FALCON AREA WATER AND WASTEWATER AUTHORITY - WATER TREATMENT PLANT

GRADING & EROSION CONTROL PLAN

CCES Responses

PPR2314

FALCON AREA WATER AND WASTEWATER AUTHORITY - WATER TREATMENT PLANT GRADING AND EROSION CONTROL PLAN

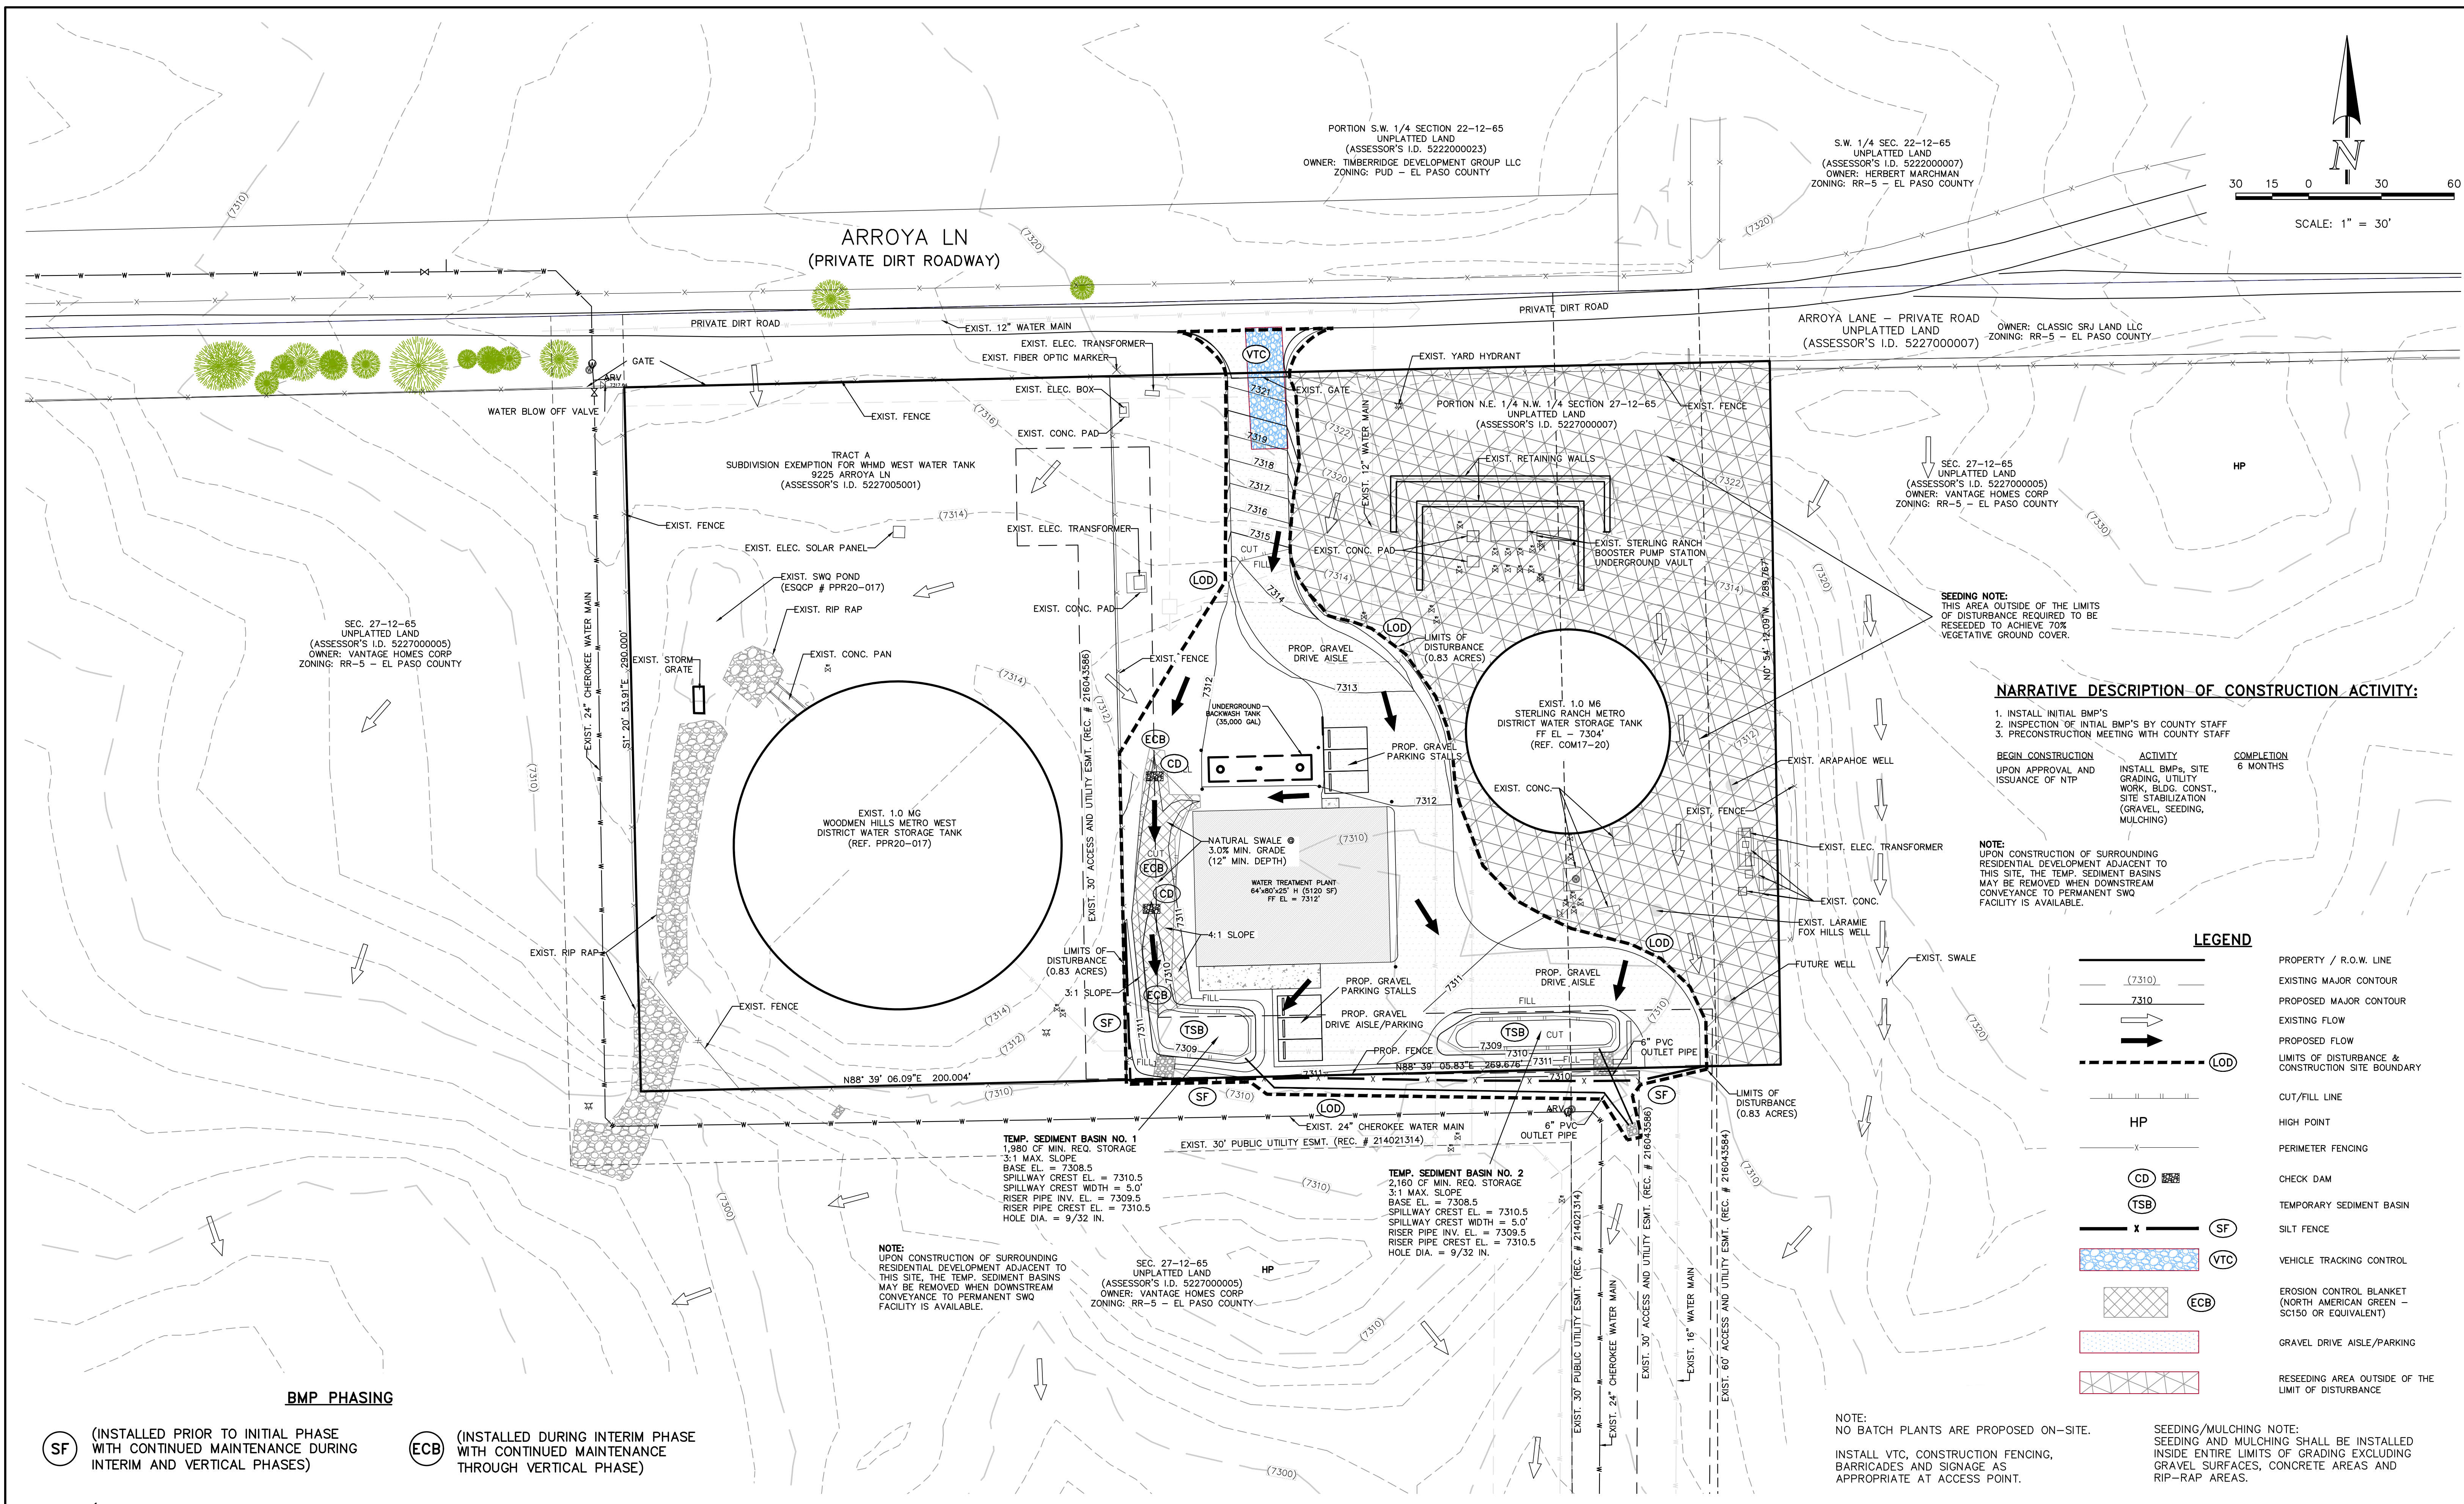
Show all areas of existing disturbance that will need to be accounted for in disturbance total and stabilization measures.

Show all areas of cut and fill on the plans.

Added GEC Checklist Item B. Label adjacent city/town/jurisdictional boundaries, subdivision names, and property parcel numbers

Updated Shift VTC over for trucks leaving the construction site.

Updated show proposed WQ Pond and include existing ESQCP number for this Parcel (PPR2017)

Revised show gray riprap hatching and remove dashed line so that its not confused with the limits of disturbance

Revised call out drainage pathway and provide details, including type of riprap, riprap gradation, width, slopes, longitudinal slopes, filter fabric, etc.

Revised GEC Checklist Item V. Label all proposed temporary construction BMPs by phase of implementation (initial, interim, final).

Based on a site visit on 9/8/23 and attached pictures provided, all off-site disturbance as shown in the screen shot dated 7/2022 has now been revegetated and stabilized to a level of at least 75% .
